Arun District Council
Arun Civic Centre
Maltravers Road
Littlehampton
West Sussex BN17 5LF
Planning & Building Control General Enquiries
Tel: (01903) 737756 Fax: (01903) 730442
Dx: 57406 Littlehampton
Minicom: 01903 732765
e-mail: planning@arun.gov.uk
website: www.arun.gov.uk/planning

Application No: WA/50/20/RES
Site Address: Former Lanes End House West Walberton Lane Walberton BN18 0QS
Description of works: Approval of reserved matters following outline consent WA/26/18/OUT for appearance, landscaping, layout & scale for the demolition of 1 No. dwelling & the erection of 6 No. dwellings (resubmission following WA/7/19/RES).

Thank you for your internet representation made on 25th October 2020 which has been recorded as an objection with the comments as follows:

PLOT 6
FLOOR PLANS AND
ELEVATIONS

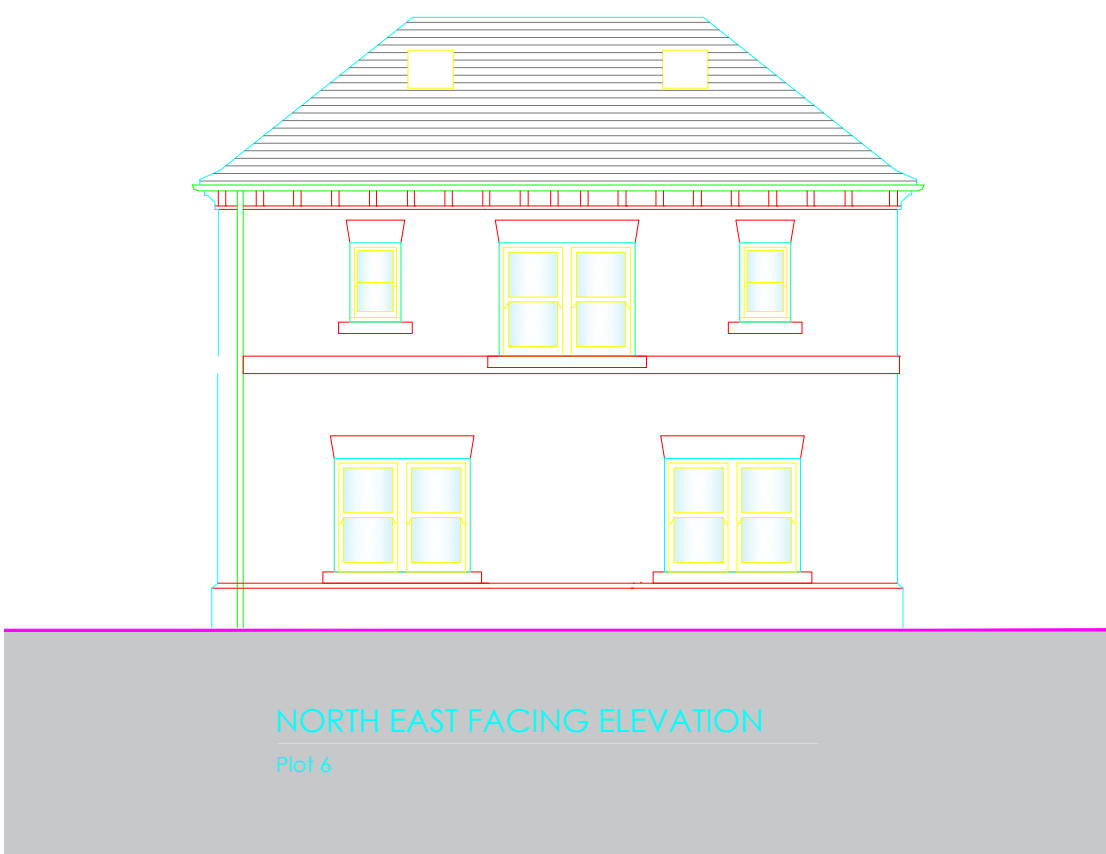
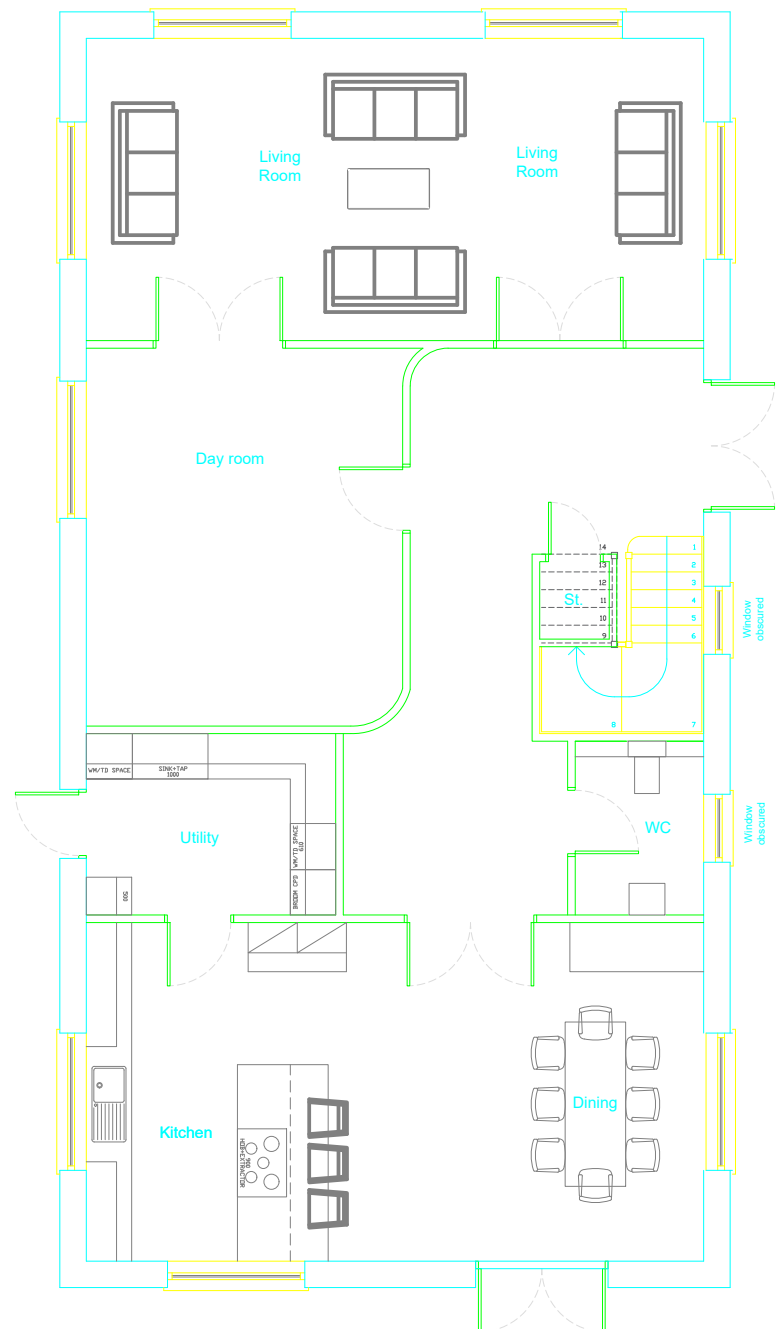
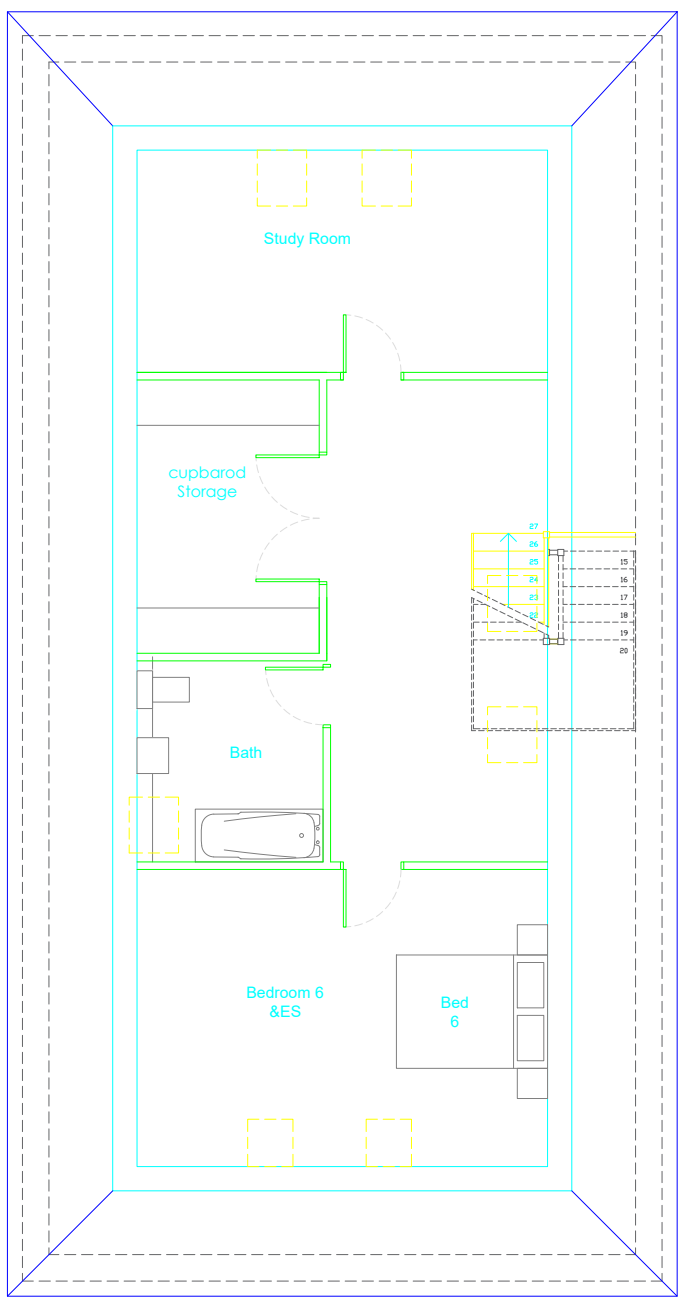
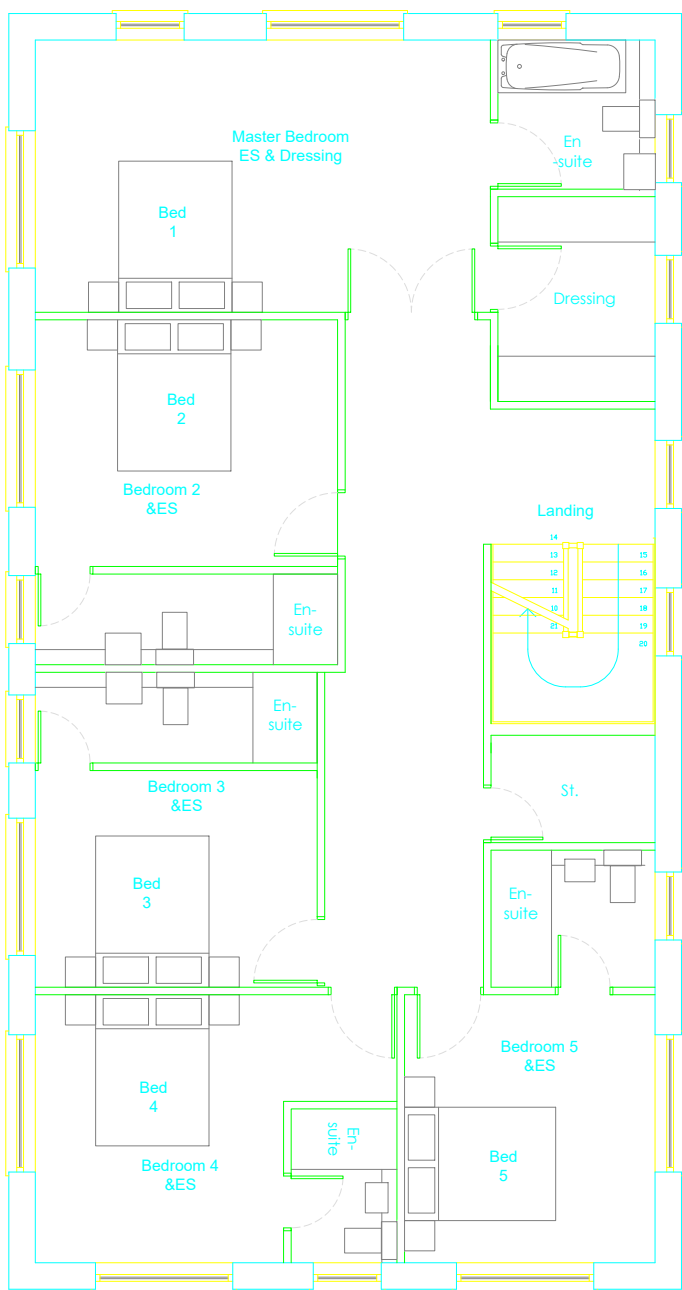
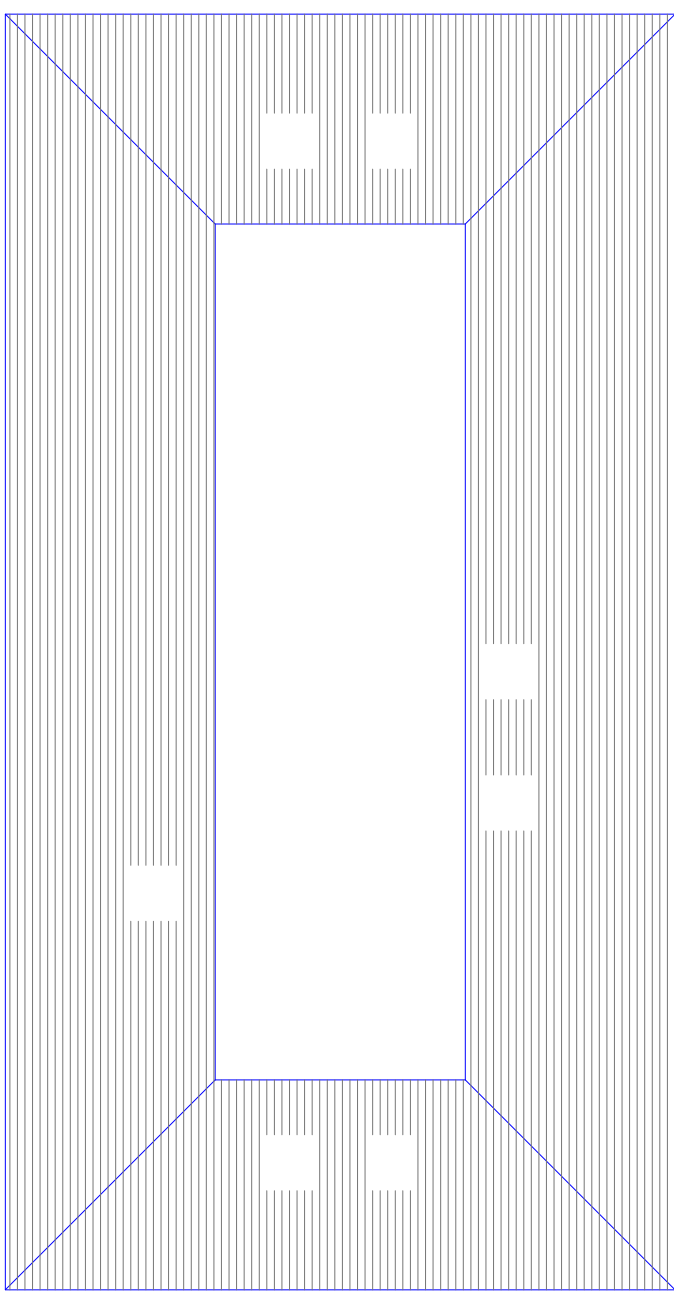
The layout of the Application differs from the Outline which showed Units 3 to 6 were further north and only the Gable end of Unit 6 overlooked Woodland whereas in this Application the whole of the eastern elevation upper windows of Unit 6 look directly into the bedrooms at the western end of the house and into the fully glazed conservatory.

6.2 Extended Phase 1 Habitat Survey Map

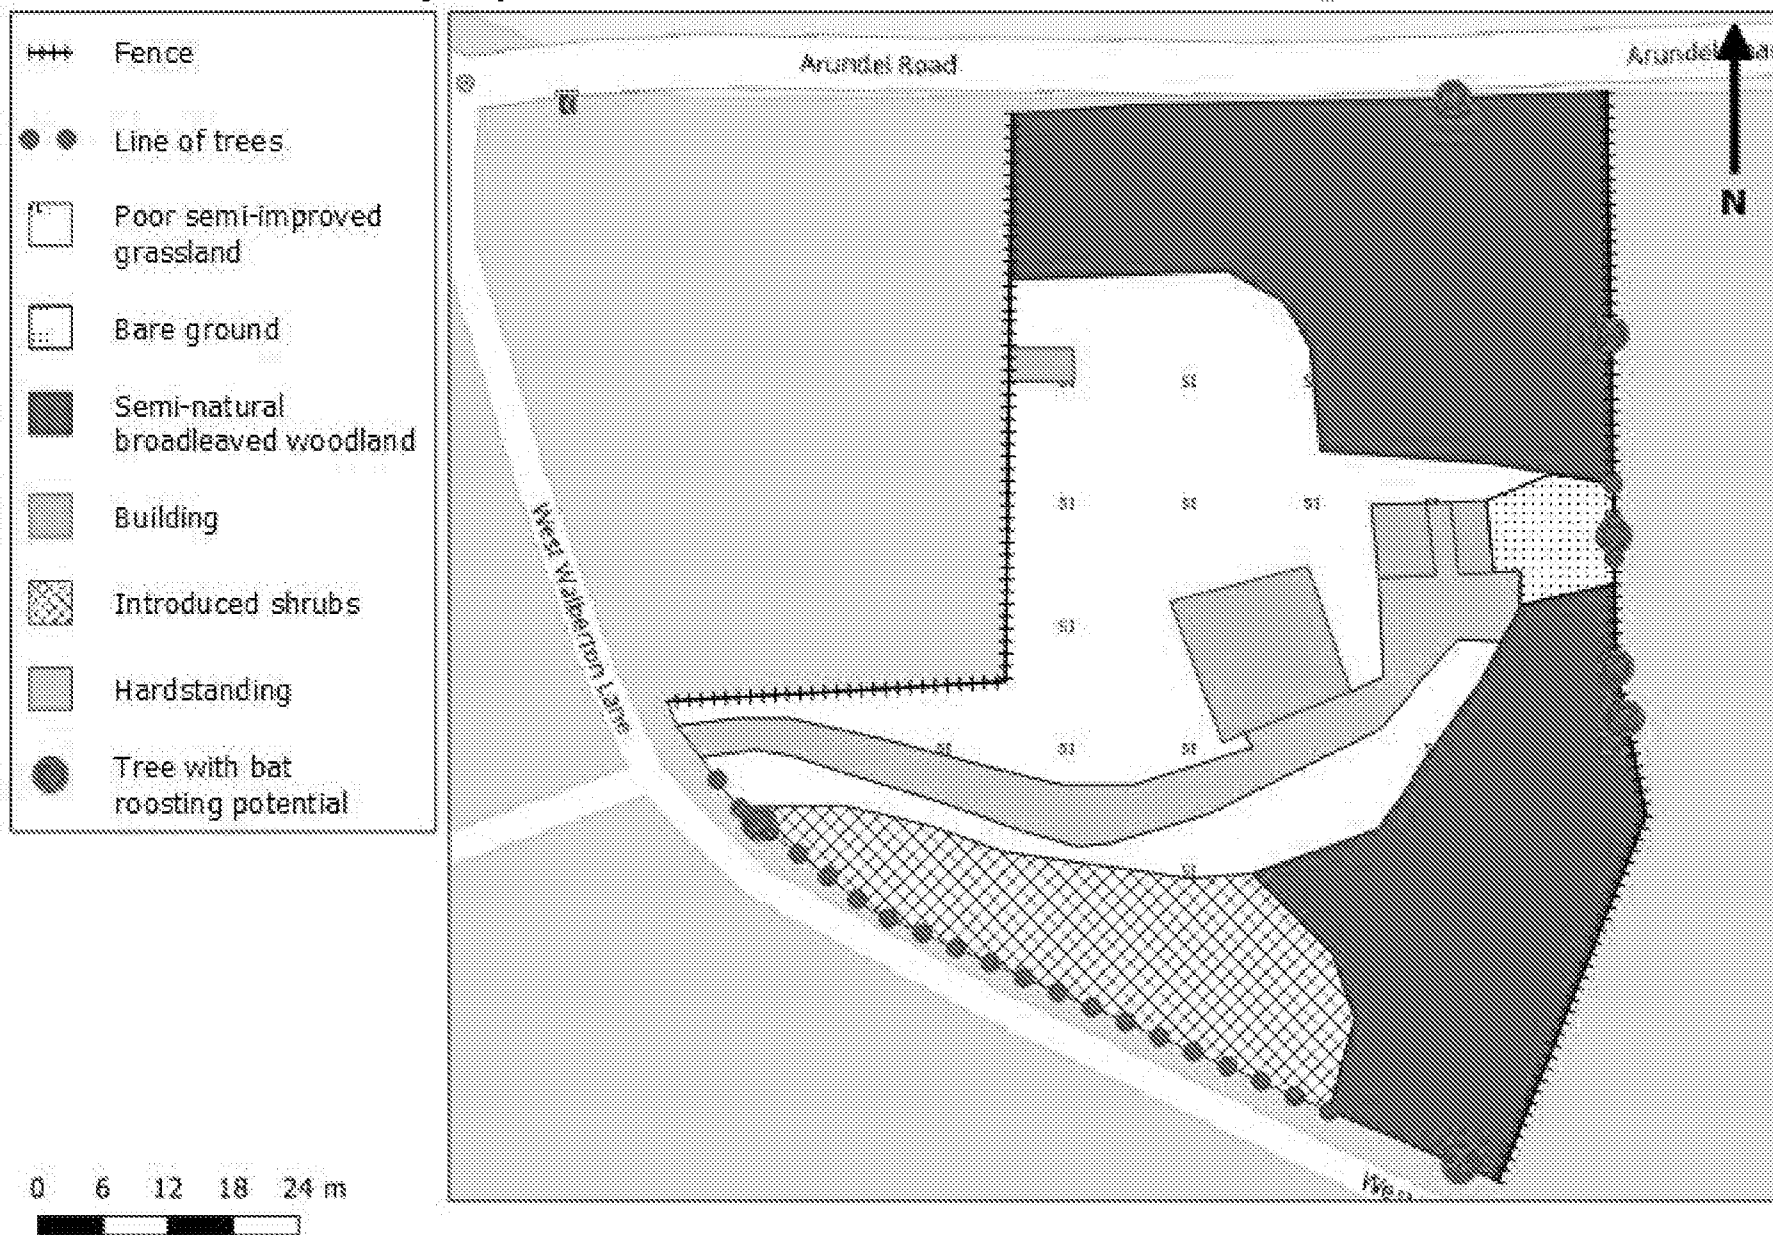
The further removal of the high value woodland see page 19 and 22 of the Ecology Report will have an effect on the wildlife and also change the outlook from a rural scene to an urban estate.
